KIRKLEES METROPOLITAN COUNCIL INVESTMENT & REGENERATION SERVICE

DELEGATED DECISION TO DETERMINE PLANNING APPLICATIONS

Reference No:	2024/62/91126/W
Site Address:	19, Redwood Drive, Bradley, Huddersfield, HD2 1PW
Description:	Erection of single storey rear extension and hip to gable roof to garage
Recommending Officer:	Molly Storer

HOUSEHOLDER DELEGATED REPORT

PROPOSED
SIDE ELEVATION-1

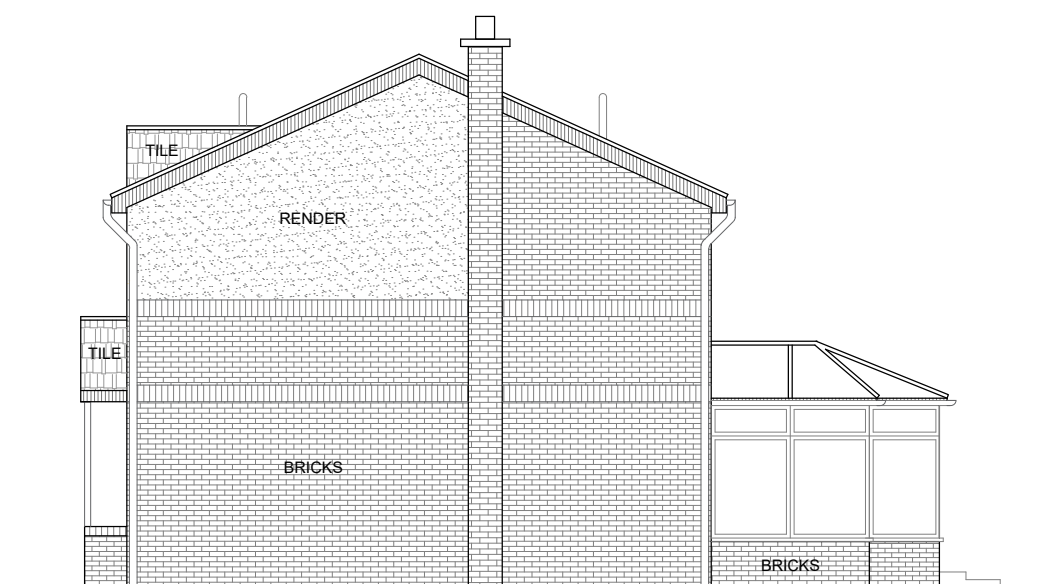
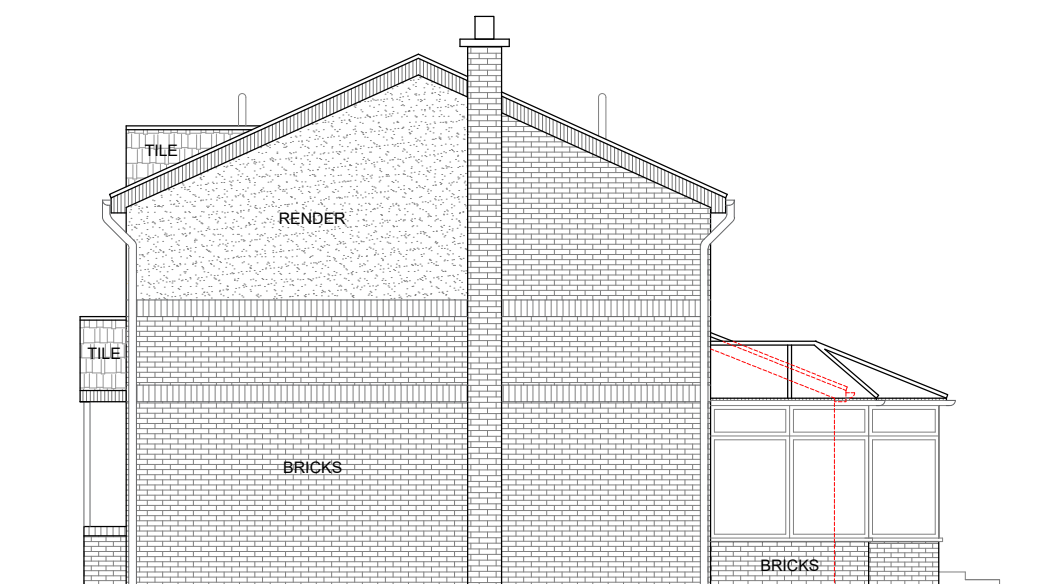
The plans show that the garages roof design will change from a hipped roof form to a gable roof form. This is considered acceptable as although there will be slightly more massing on the roof, this roof form will match that of the main dwelling and create a visually sympathetic addition.

PROPOSED
REAR ELEVATION

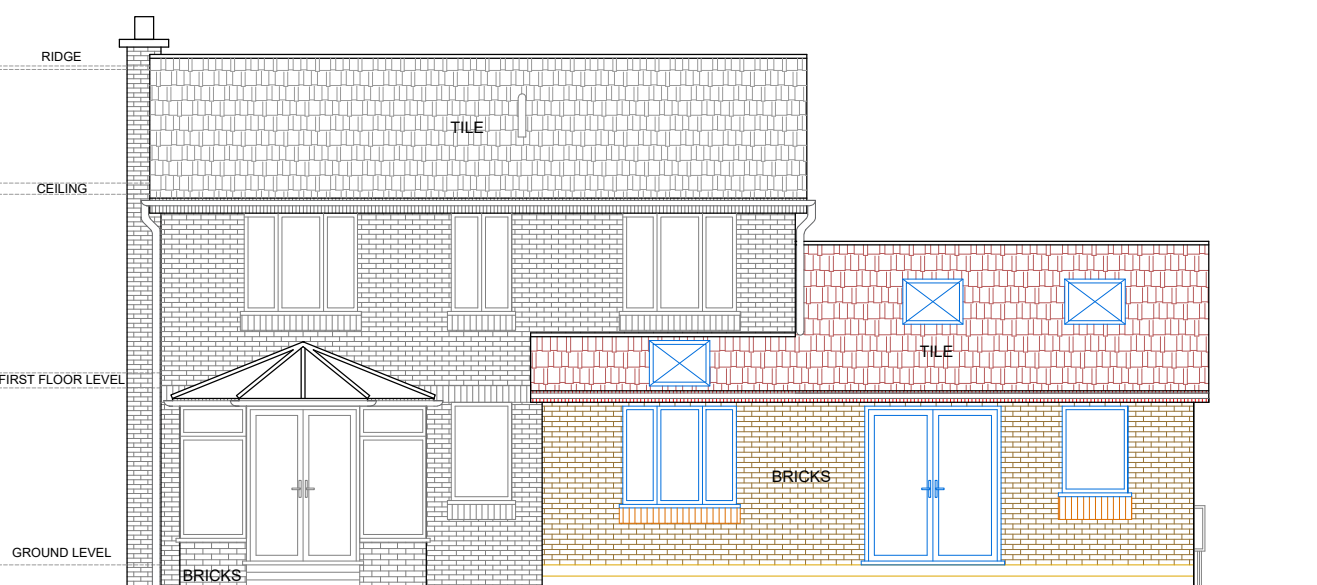
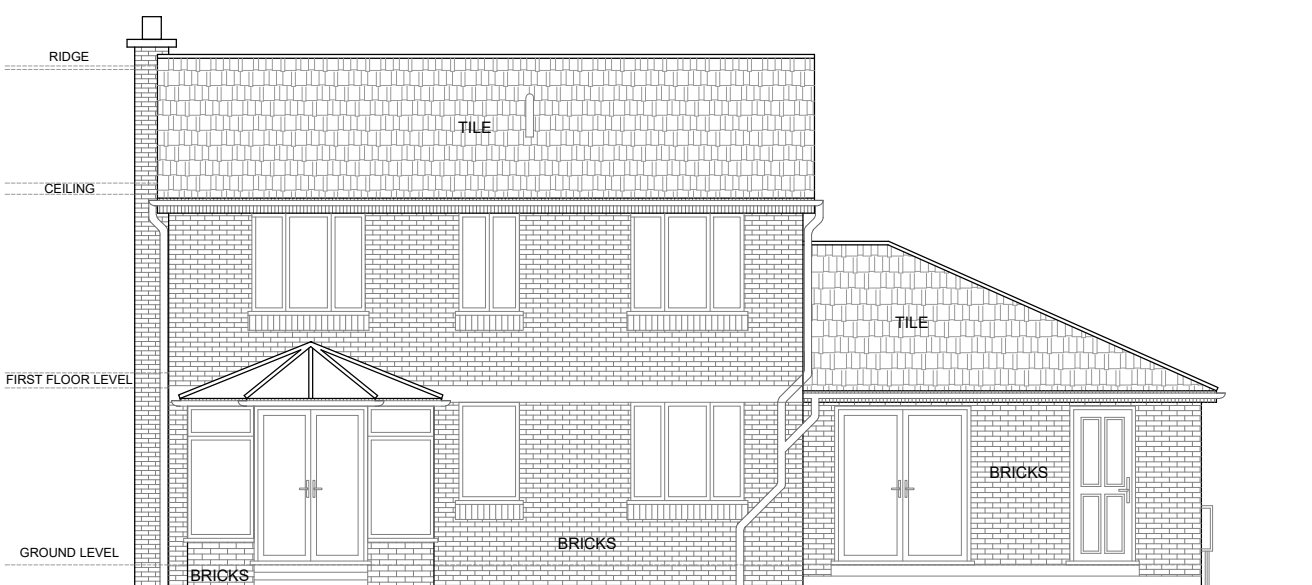
The single storey rear extension will project 1.65m from the existing rear wall of the kitchen and 1m from the existing rear wall of the living/laundry room. The full width of the extension will be 8.6m and a height to the eaves of 2.5m with an overall height of 4.5m. The roof form will have a 'wrap around' appearance with part of the roof being of a lean-to design and part of the roof following on from the garages gable roof. This will create space for an open plan kitchen and dining area. The main construction materials will be brick for the walls and a concrete tiled roof to match the existing property.

not exceed 4 metres in height		No – although part of the roof will exceed 4m in height this is considered acceptable in this case due to the roof design following on from the garage roof which creates a harmonised design.
